City of Albuquerque

Project Title: COMFORT DENTAL MENAUL Building Permit #: _____ City Drainage #: 14182068

Re: Comfort Dental Coronado, 5820 Manual Blvd, Traffic Circulation Layout
Architect's Stamp dated 07-24-13 (H18-D068)

**Re: Comfort Dental Coronado, 5820 Menaul Blvd, Traffic Circulation Layout
Architect's Stamp dated 6-05-13 (H18-D068)**

**A6 Entry Ramp / Stair Enlarged Plan**  
Scale: 3/8" = 1'-0"

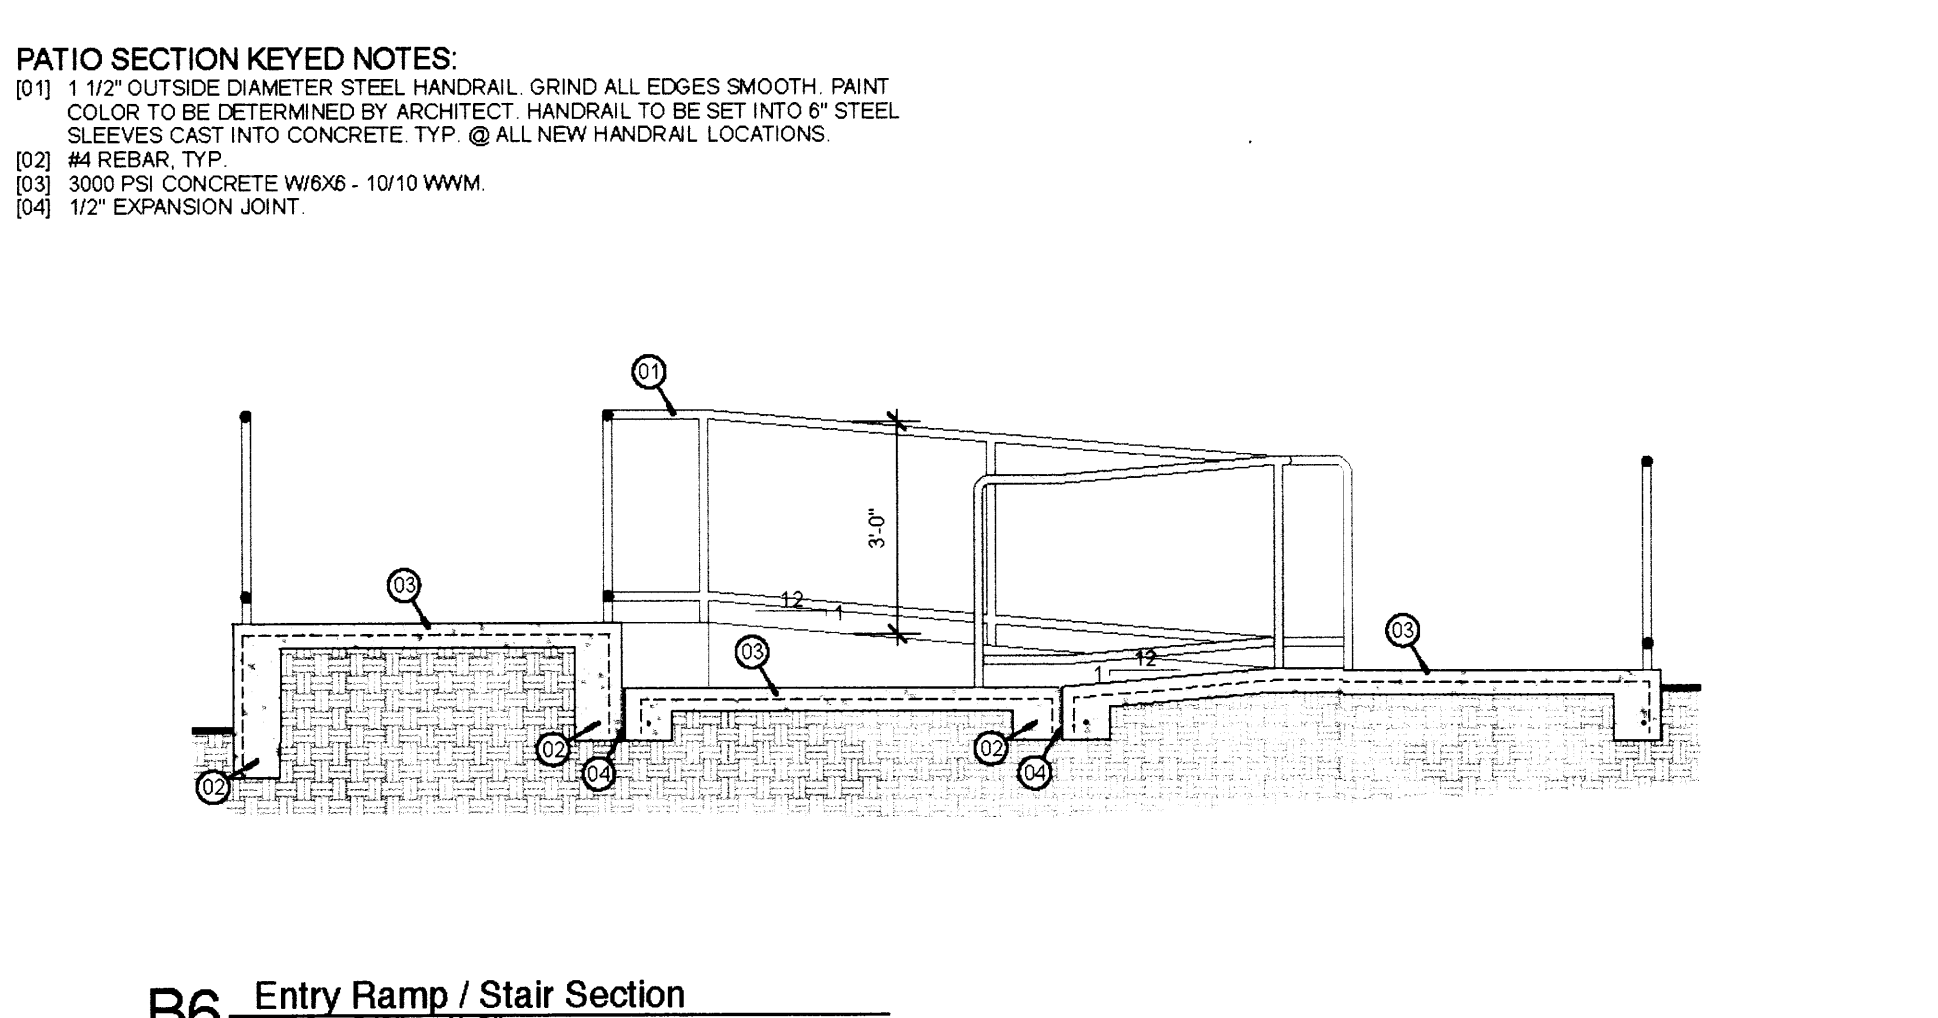
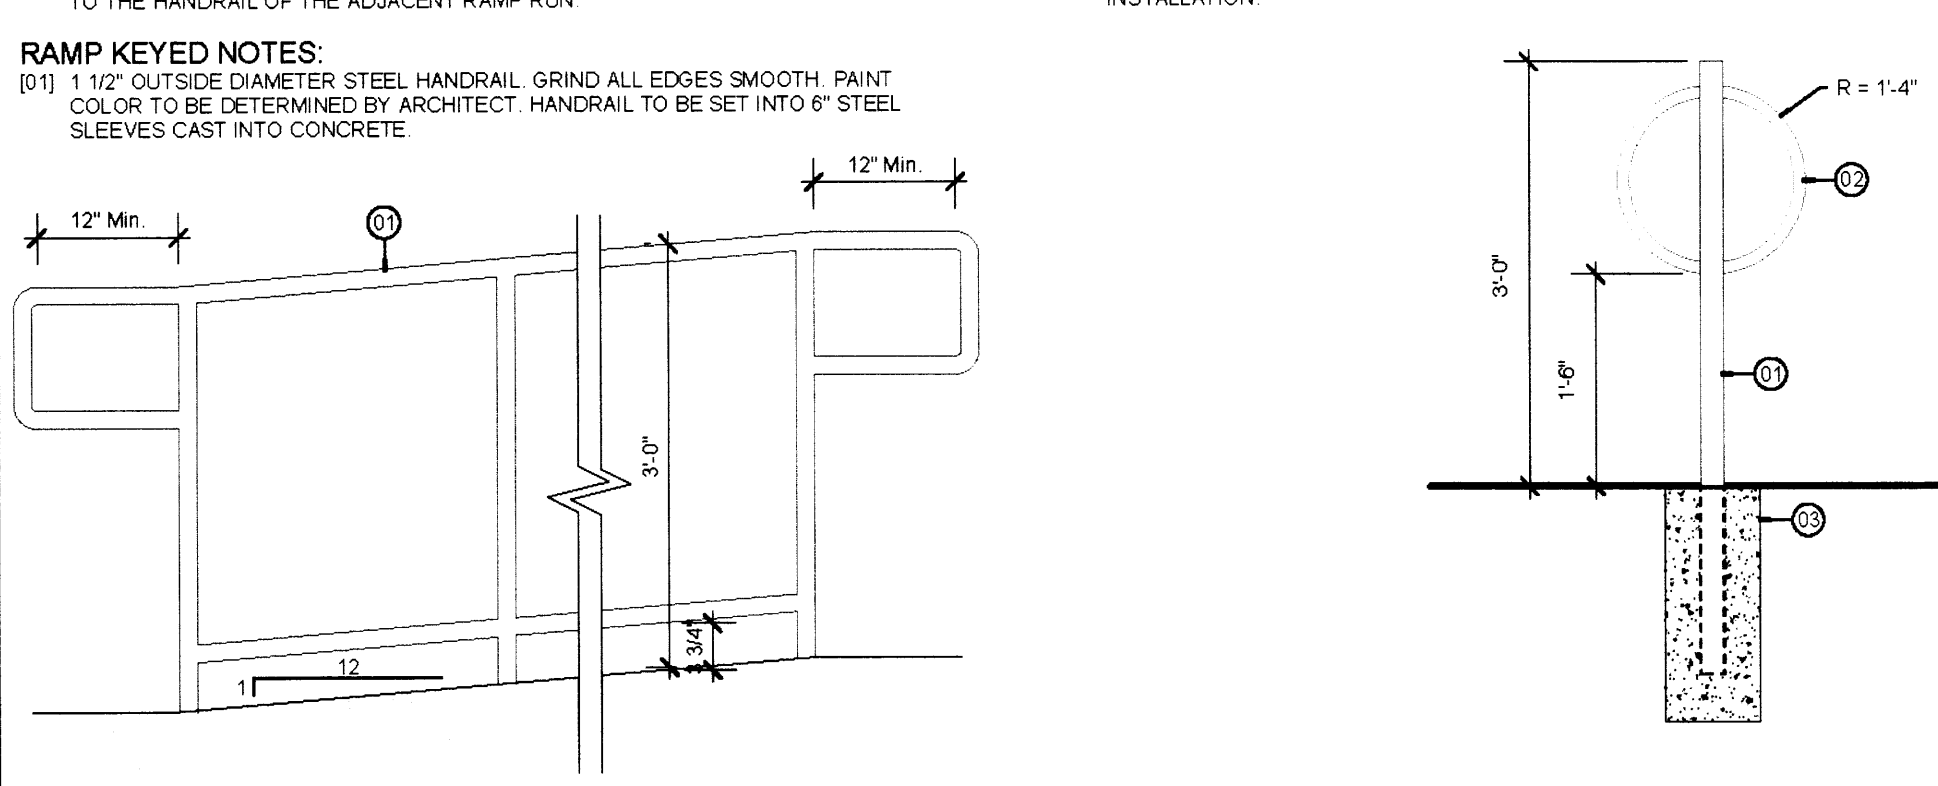
5. Please ensure ramp railing is ADA compliant, Section 505 *Handrails* and 405.9 *Edge Protection*. A curb barrier is required if space between the railing and ground surface is 4 inches or greater. An extended ground floor of 12 inch minimum required beyond inside face of handrail. Please verify compliance.

7. Please correct errors on sheets TCL.01 & .02: (1) Detail C5 cross-section mislabeled. (2) Detail C3 missing cross-section of handrail along landing. (3) Detail A1 is not accurately referenced to cross-section B3/A.202 on sheet TCL.01. (4) There is a floating keyed note "02" adjacent to motorcycle stall. (5) A keyed note "18" misused. (6) Demo line needs to be drawn correctly. (7) Keyed note "14" references "existing asphalt".

A6 Detail @ Public Sidewalk  
Scale: 3/4" = 1'-0"

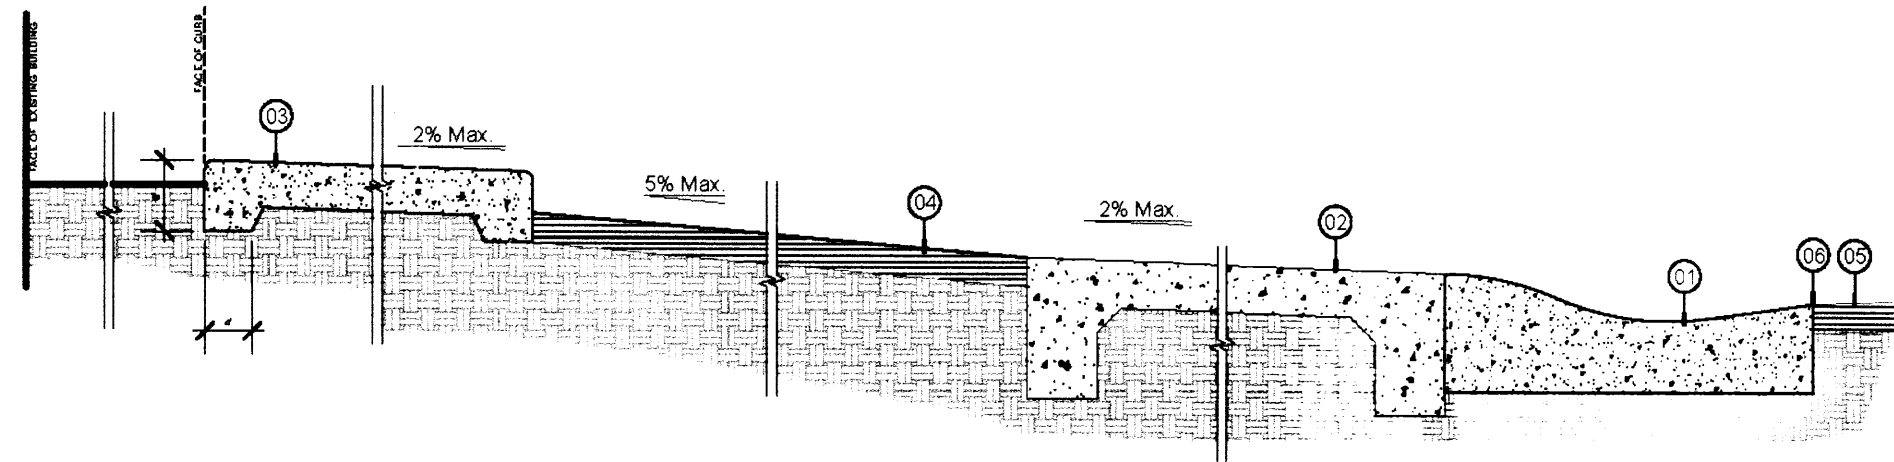
- 3' 6" 1. Define width of the existing sidewalk on Menaul and Cagua Dr.
3' 6" 2. Define width of proposed sidewalk on Cagua Dr.
dowel 3. Please provide a construction note detailing tie-in of existing concrete sidewalk and curb/gutter to proposed concrete infrastructure.

D4 Site Plan  
Scale: 1" = 10 ft

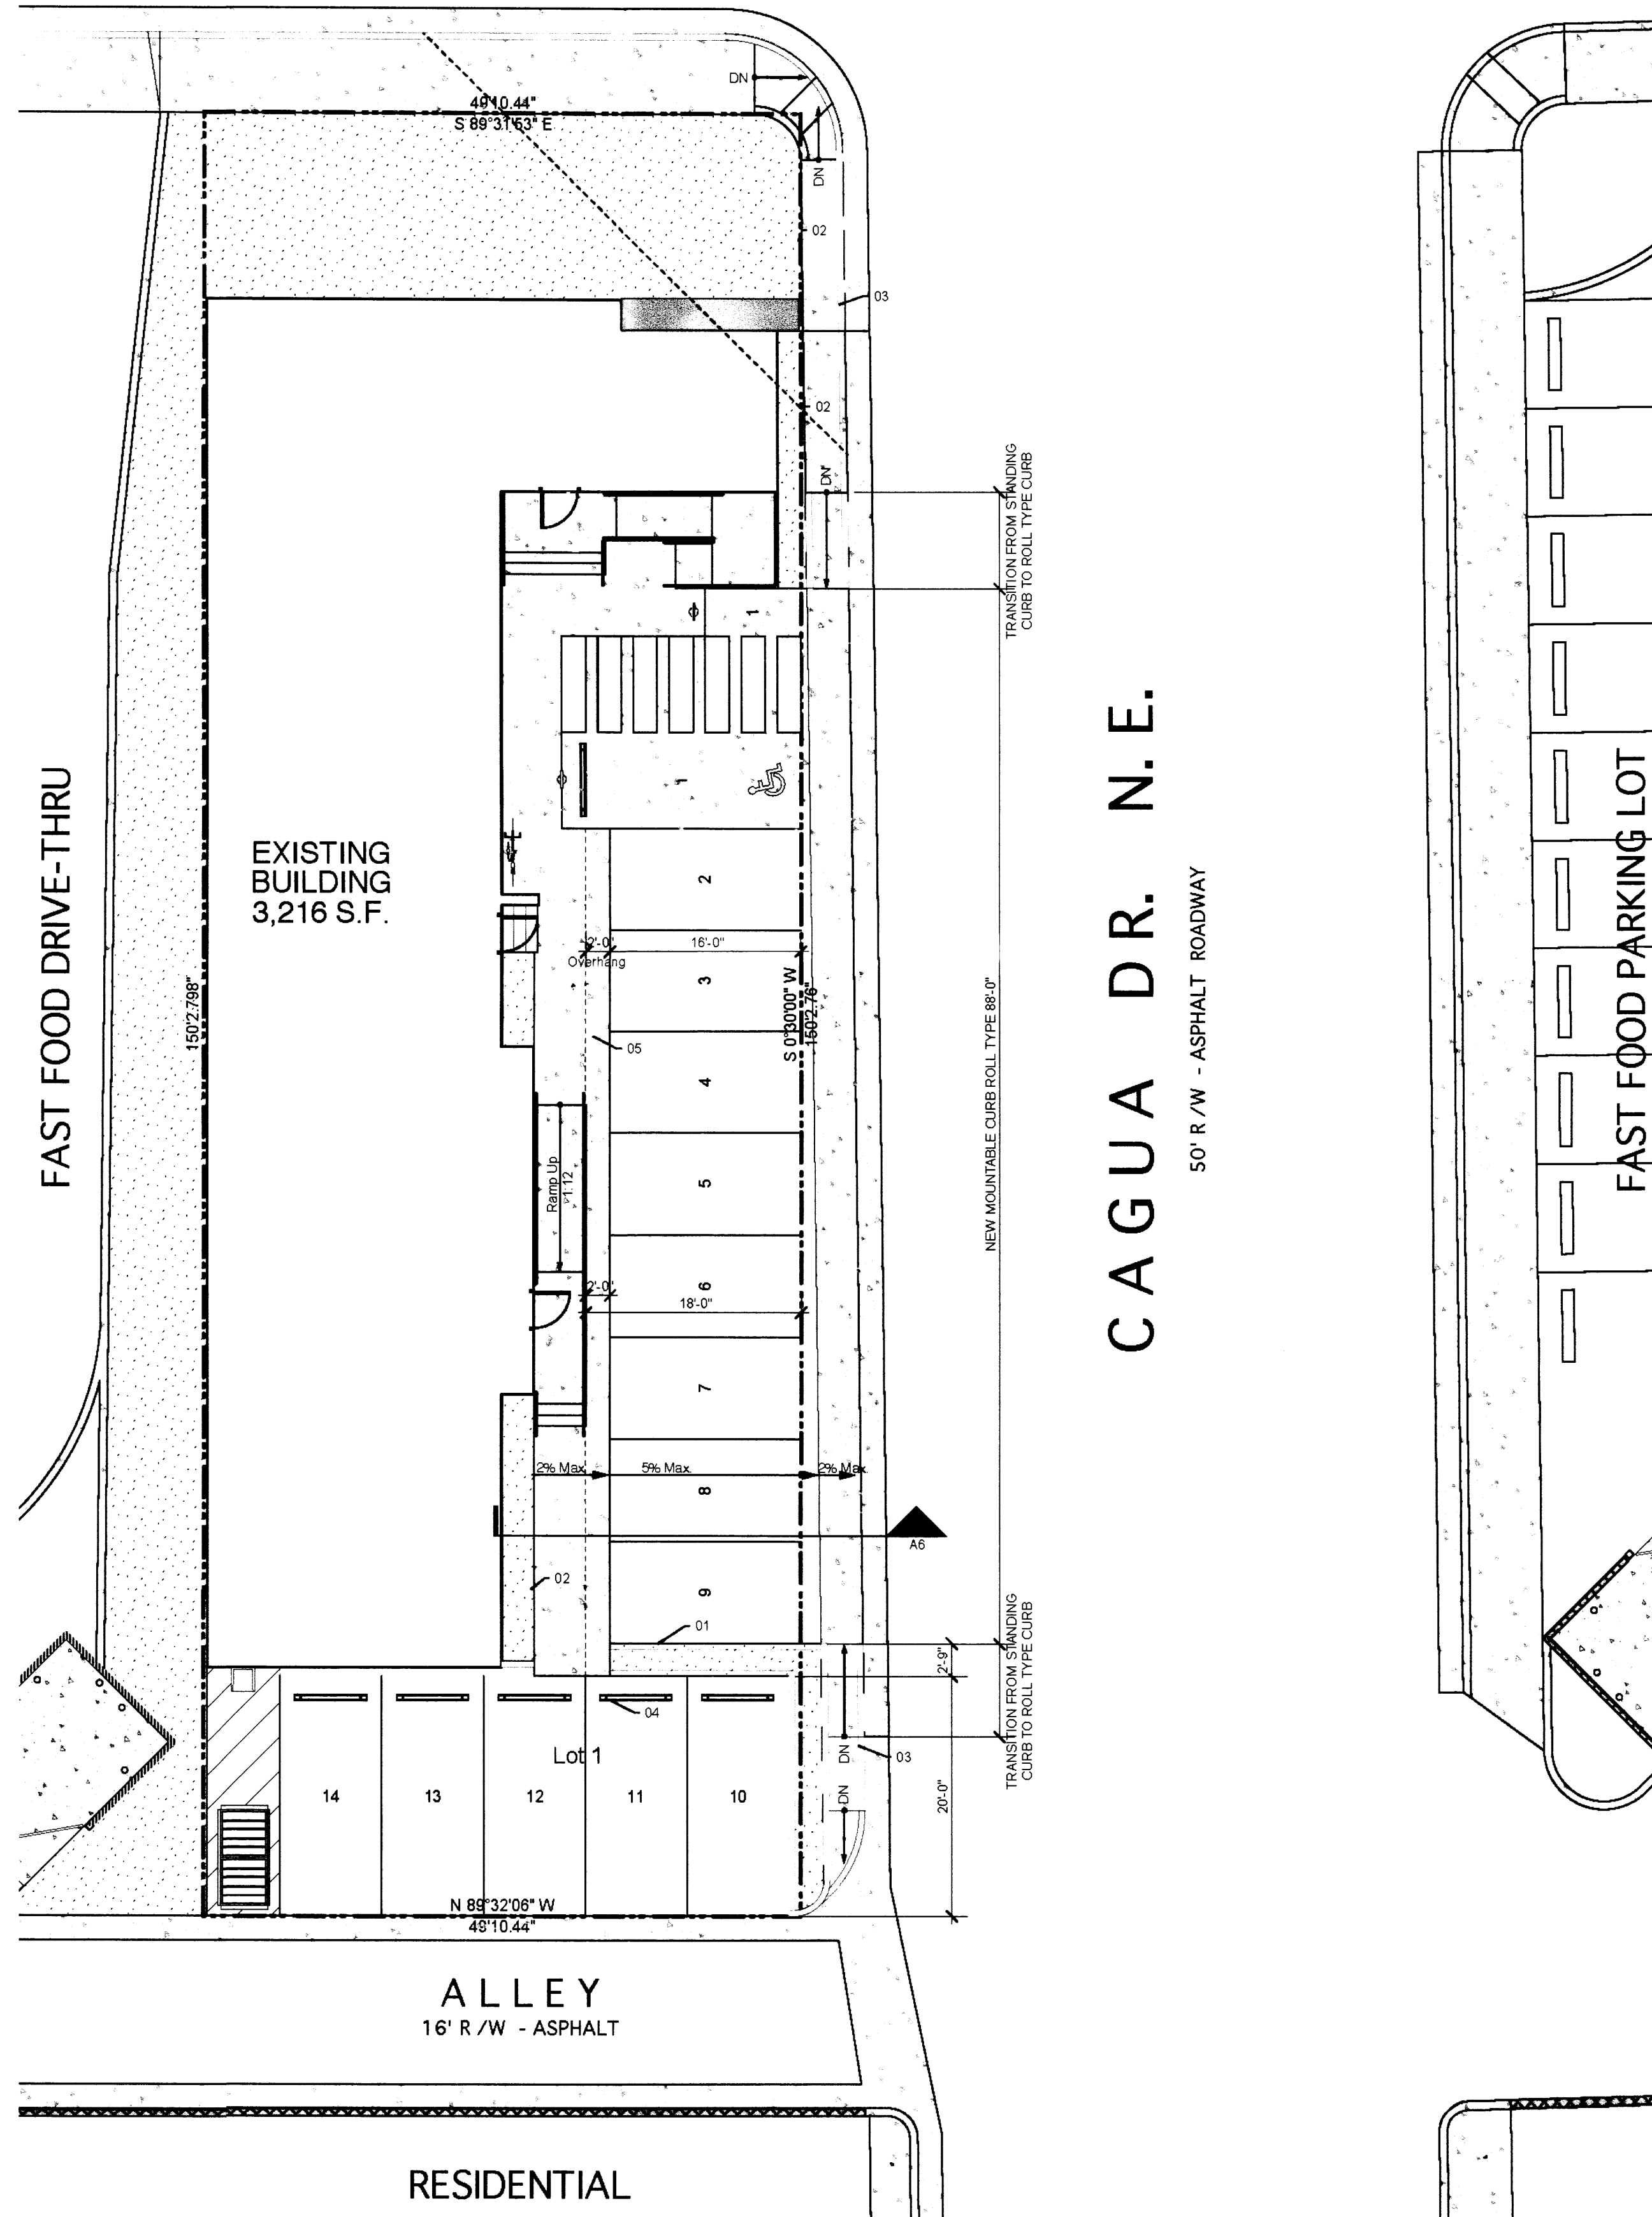
4. The proposed sidewalk adjacent to valley gutter must be design to keep street drainage off of private property. A water-block must be provided: a rise of 0.67 ft from flow-line of gutter to property line. Perhaps providing 3 ft width of sidewalk at 2% vertical slope adjacent to gutter and then increasing the slope to the property line will provide the necessary requirements. Please contact our hydrology department for further assistance: Curtis Cherne 924-3986.

8. Demo plan conflicts with proposed site plan. Please differentiate between new concrete proposed and existing to remain. There are inconsistencies between demo and proposed.

10. Per DPM, Chapter 23 Section 7.B.6 *Curbing*, Curbing should be used to separate landscaping from parking areas and pedestrian ways.
11. It appears the proposed sidewalk adjacent to the building is flush with the asphalt parking area with a 6 inch header curb as a separation to be used as a wheel-stop strip. This header curb is a tripping hazard for this application. A pre-cast concrete wheel-stop at each stall is recommended.

12. Per ADA, Section 406 *Curb Ramps*, the existing sidewalk section between the proposed sidewalk ramp and the existing sidewalk ramp acts as a landing and must provide a minimum length of 48 inches (at approach to alley). Please verify.
